Your Ref: OWPC502
Our Ref: AB/57/13/A
Please ask for:
Mr J Smith

Town & Country Planning (Control of Advertisement) (England) Regulations 2007 (as amended)

2 No. fascia signs & installation of LED trough light to East & South elevations
Martin McColls 5 High Street Arundel

Client	McColl's
Address	6242 Arundel
Project	New signage
Issue No.	07
Date	05-06-13
Scale	
Drawn	Chris Szramek
Approved / Date

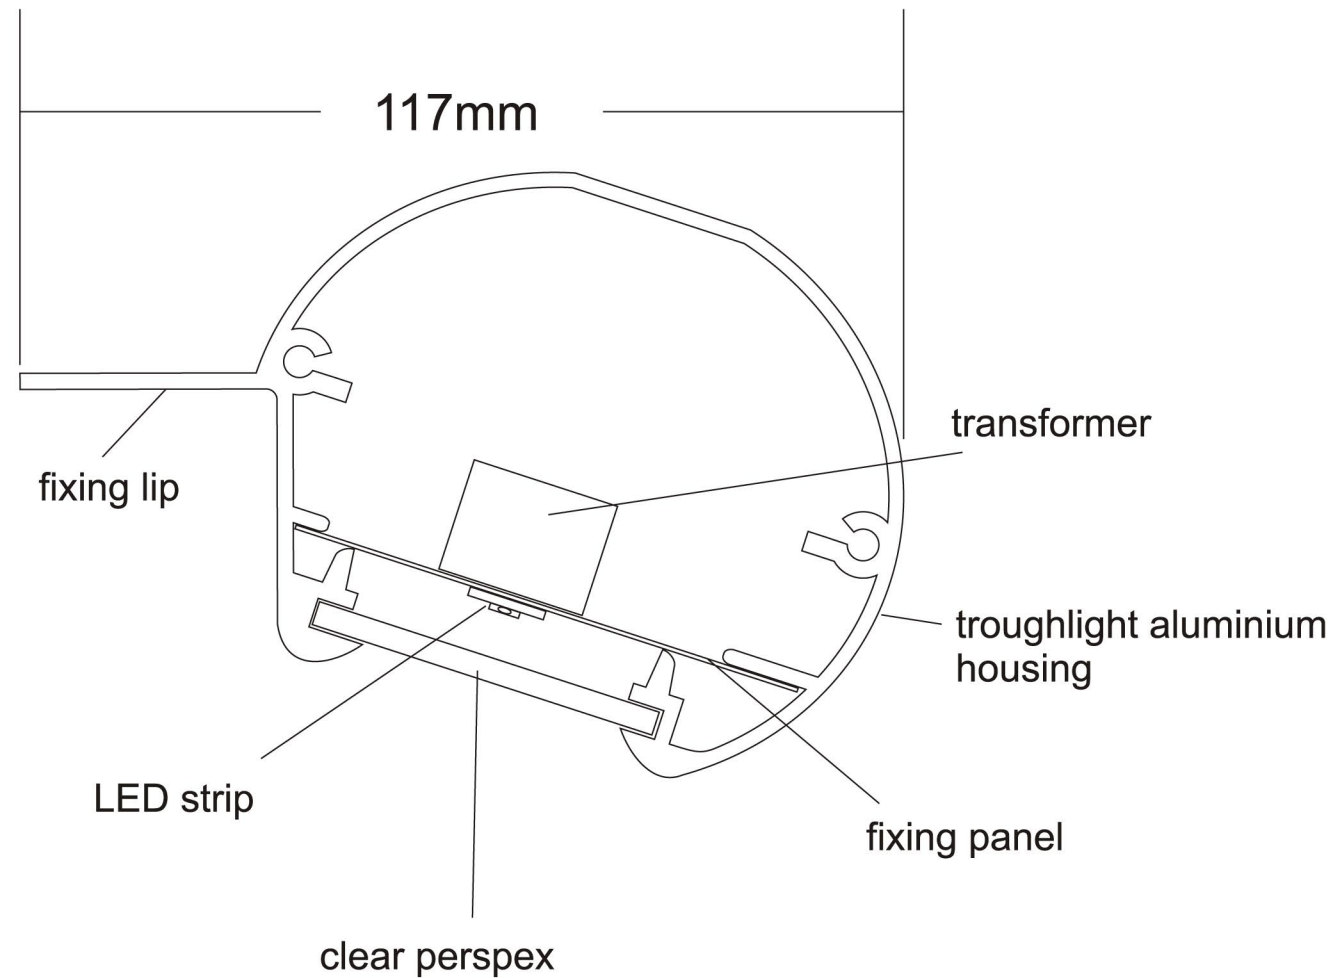
Strong objection - council felt that adverts not in keeping with conservation area in historic market town
